102 E. Pikes Peak, Suite 500  
Colorado Springs, CO 80903  
(719) 955-5485

January 15, 2020

**RE: Homestead at Sterling Ranch Filing No.2  
Response to Comment Letter.**

HOMESTEAD AT STERLING RANCH FIL. NO. 2			
SAND FILTER PONDS LOTS 13-24			
PROJECT NO. 09-007	FILE: Yang\Const.Dwg\Street & Storm Plans\ST11.dwg	DATE: 11/19/2019	SHEET 11 OF 14 ST11
DESIGNED BY: CMM	SCALE: 1"=10'	VERT: N/A	
DRAWN BY: CMM	CHECKED BY: VAS

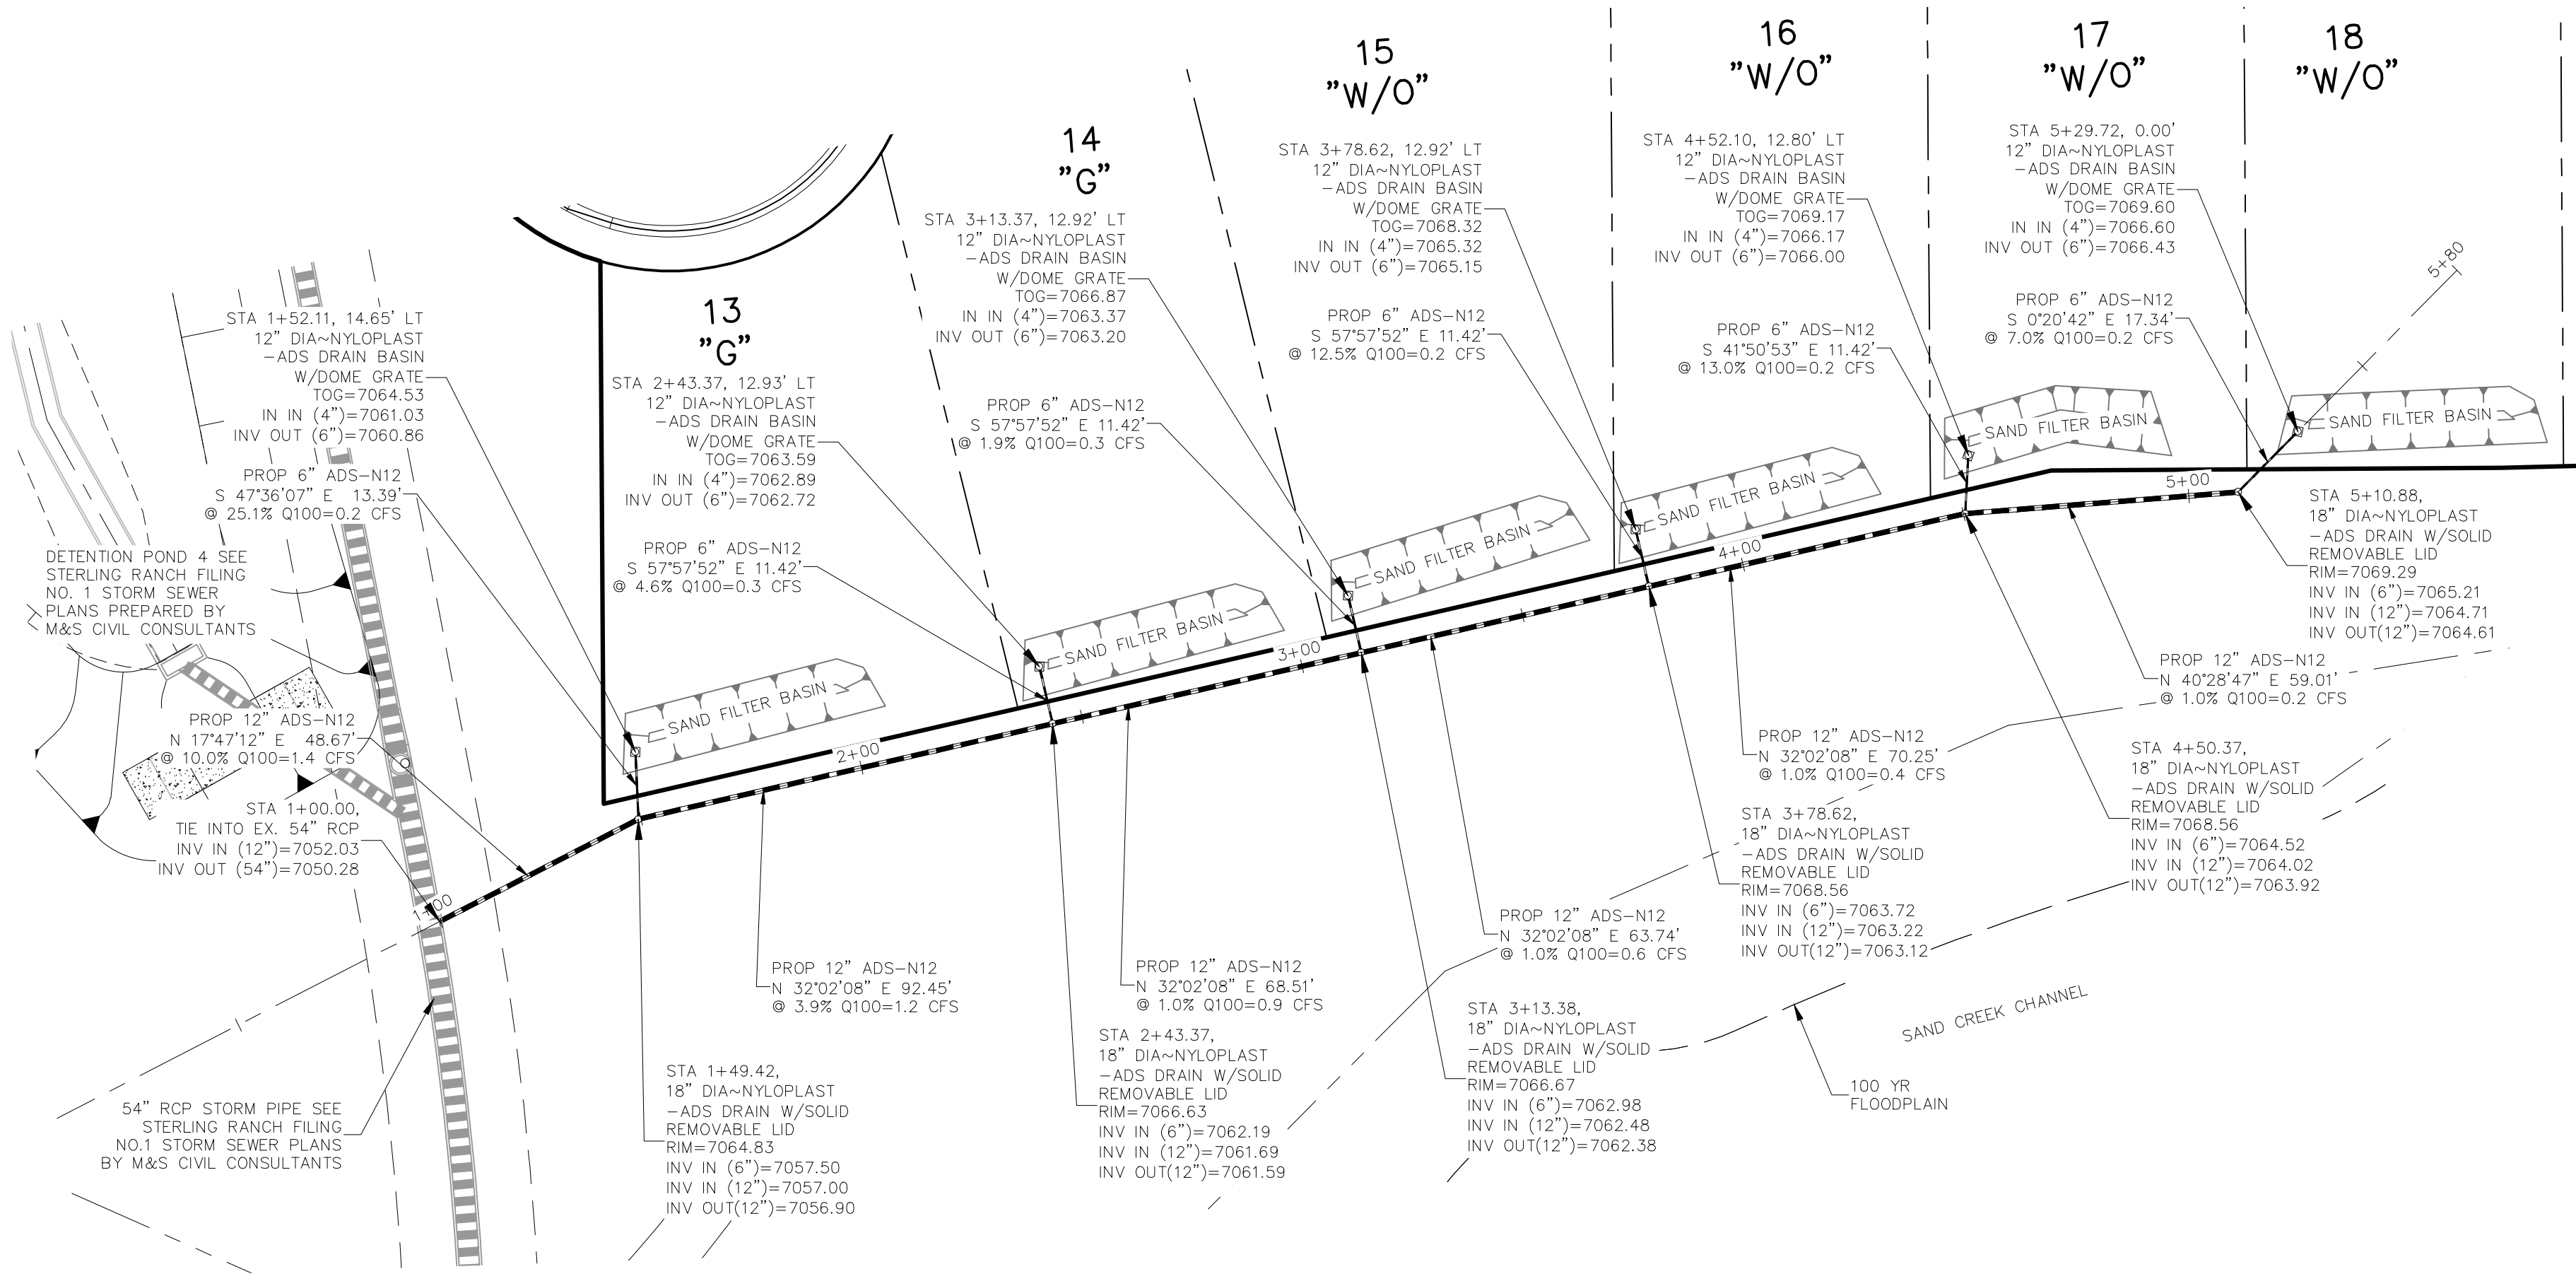
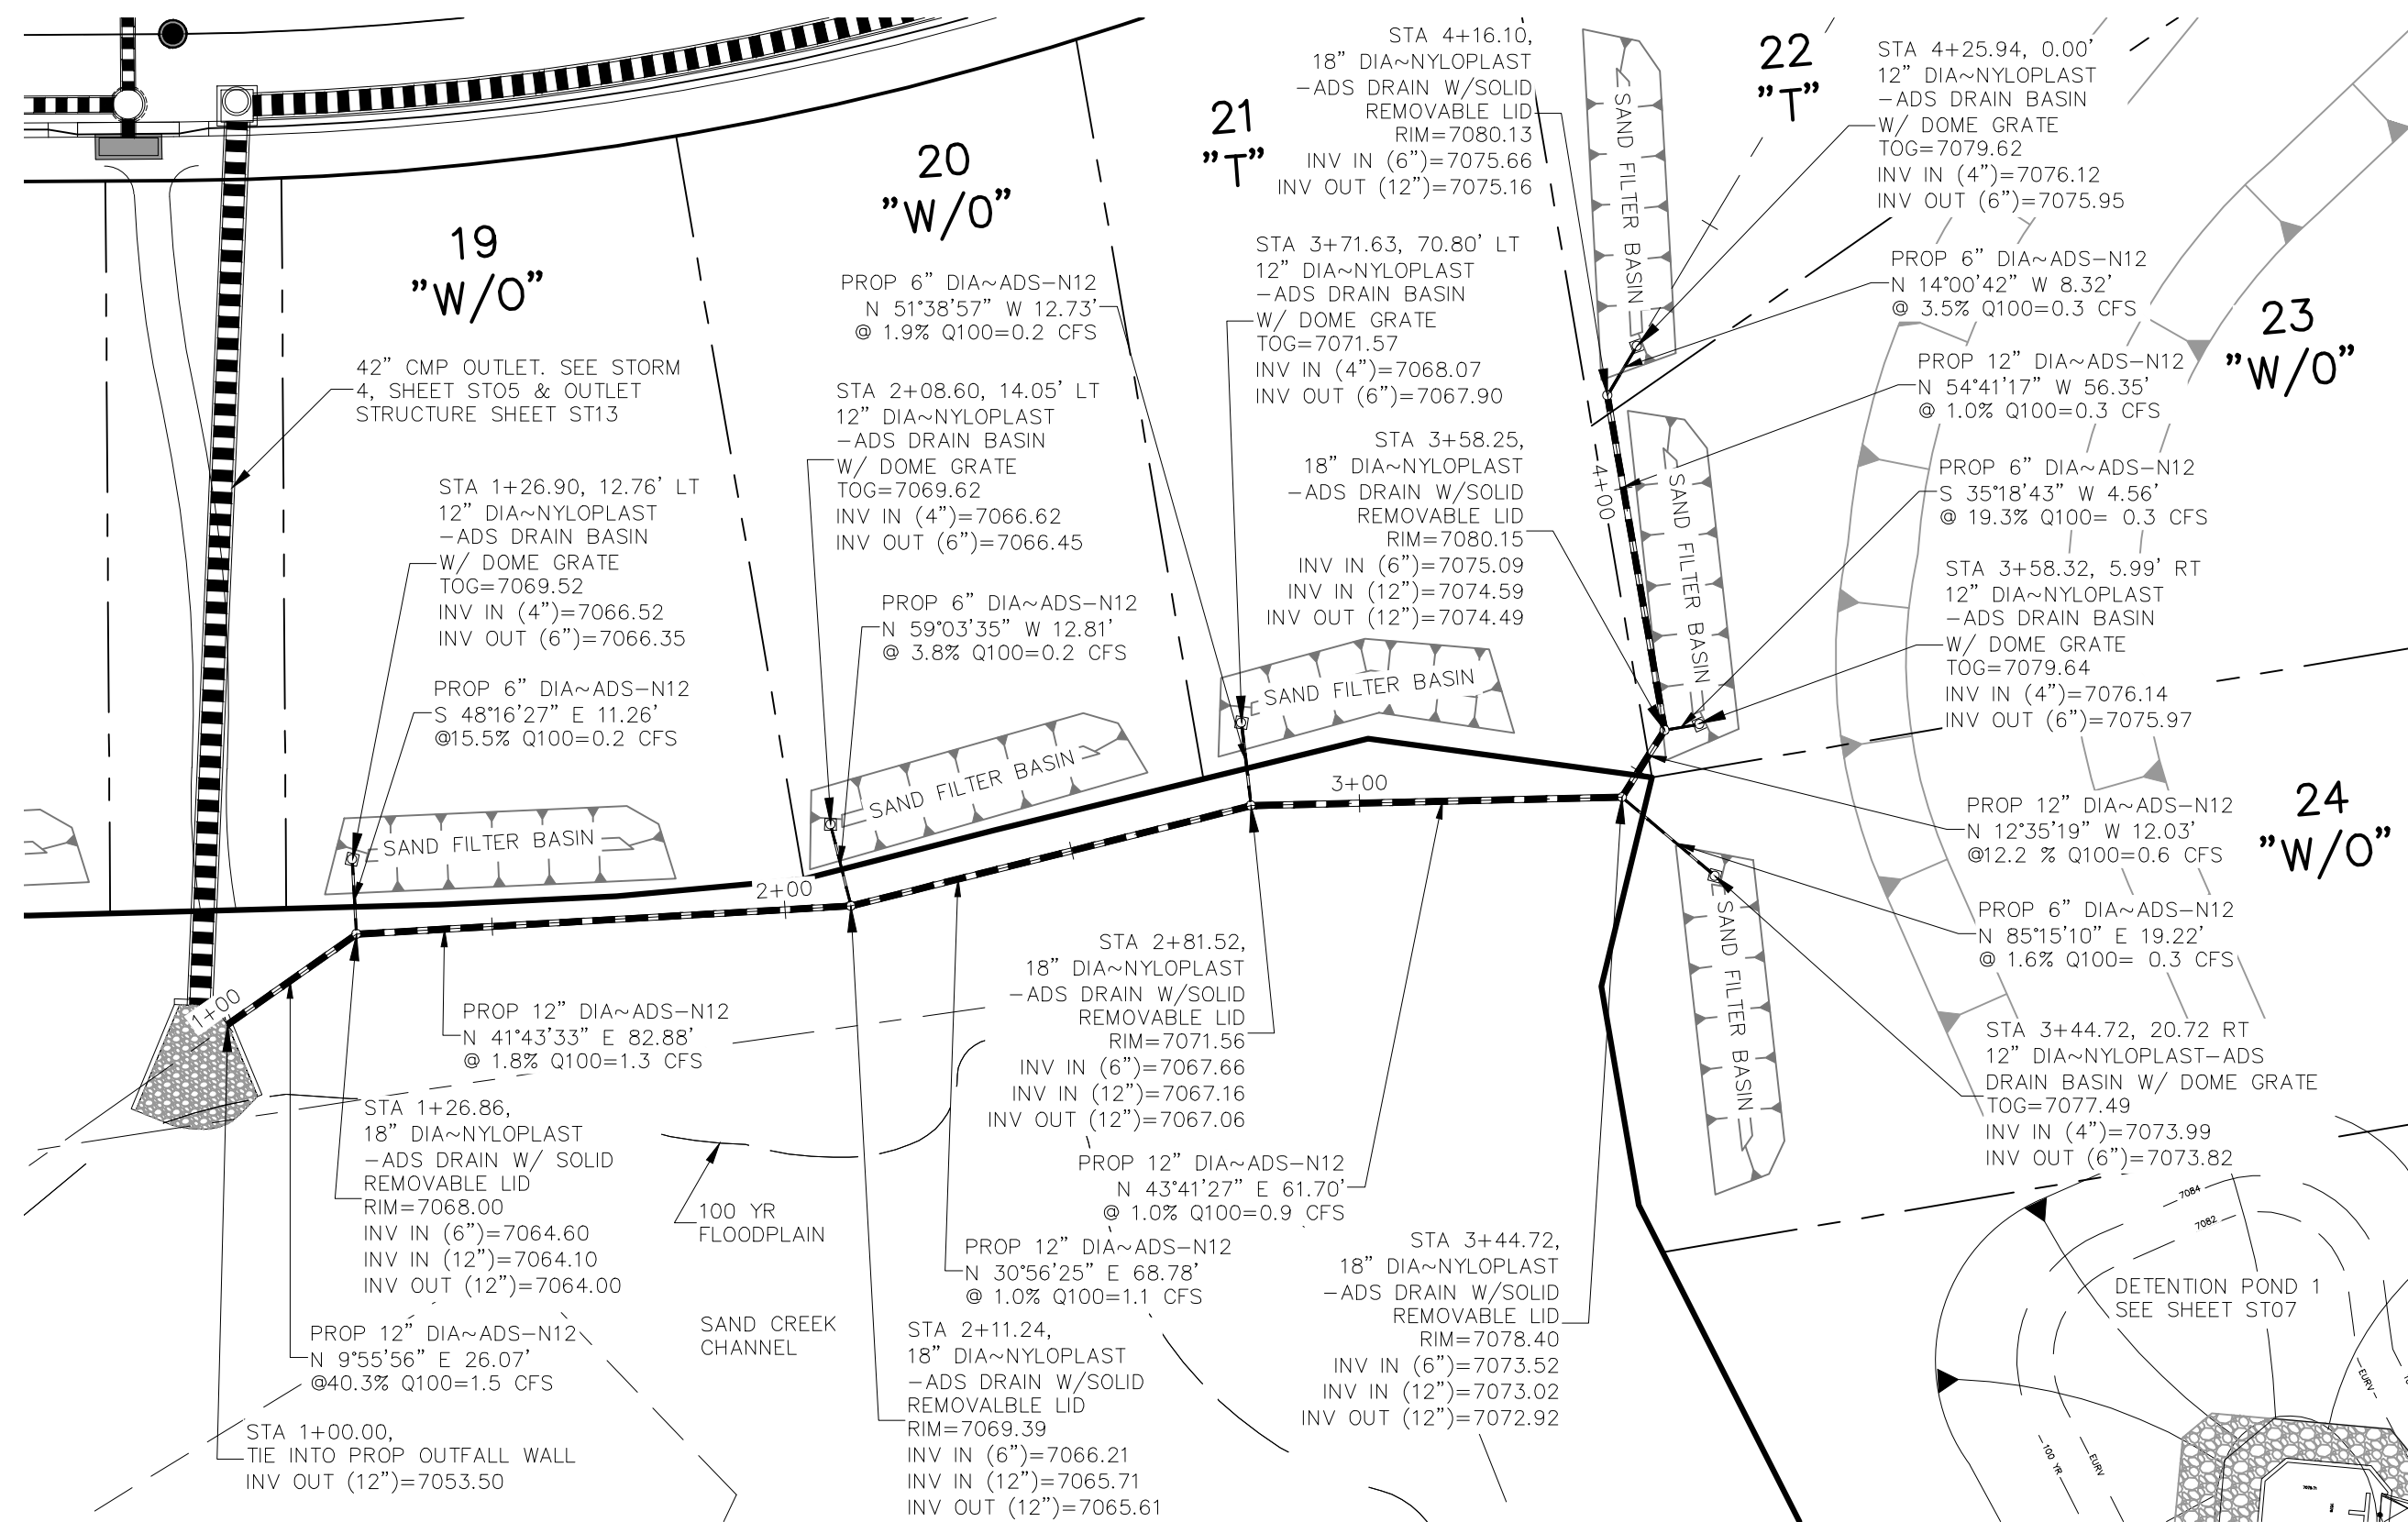
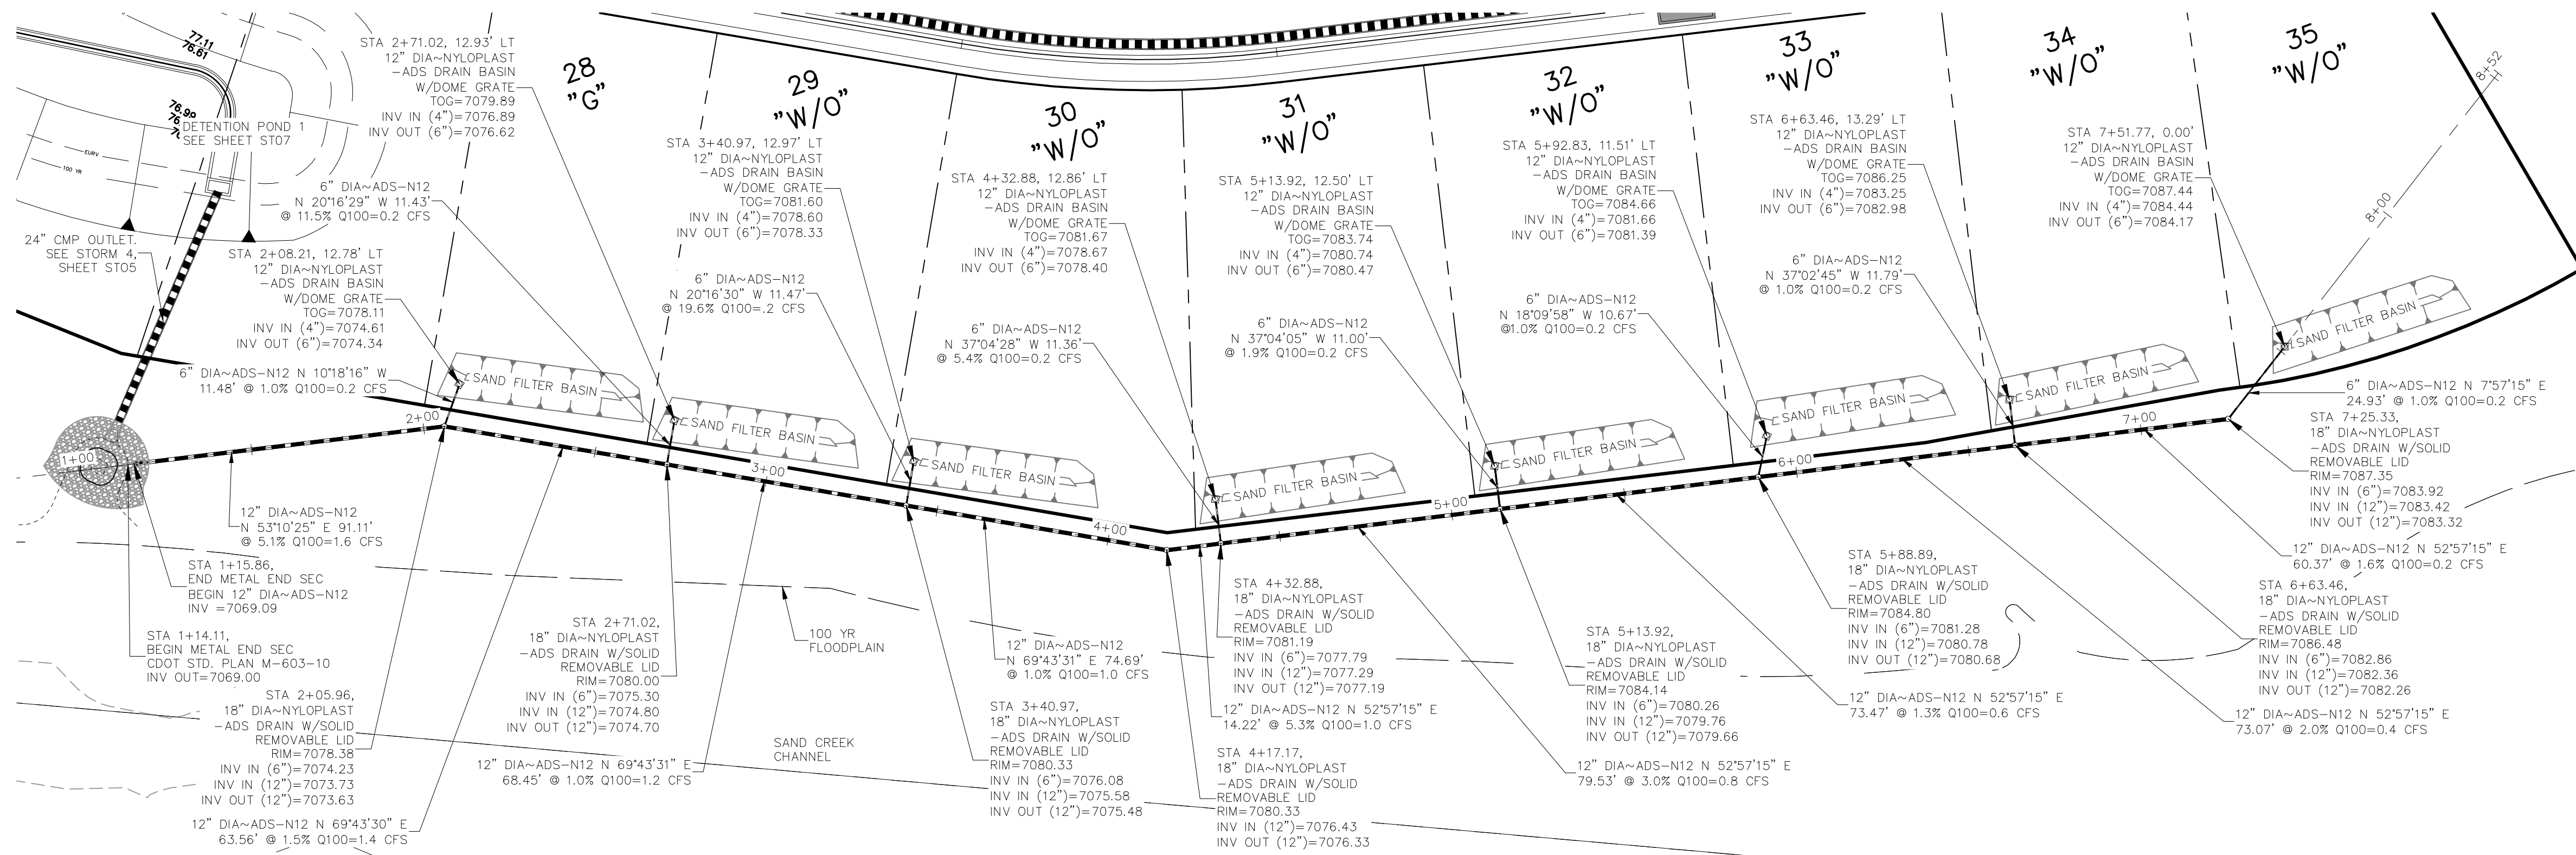
9. **Additional discussion is necessary regarding the multiple SFBs proposed in the rear yards along the creek. O&M manual and maintenance agreement details need to be complete.**  
**Additional discussion has been added to the FDR and details added to the O&M manual.**
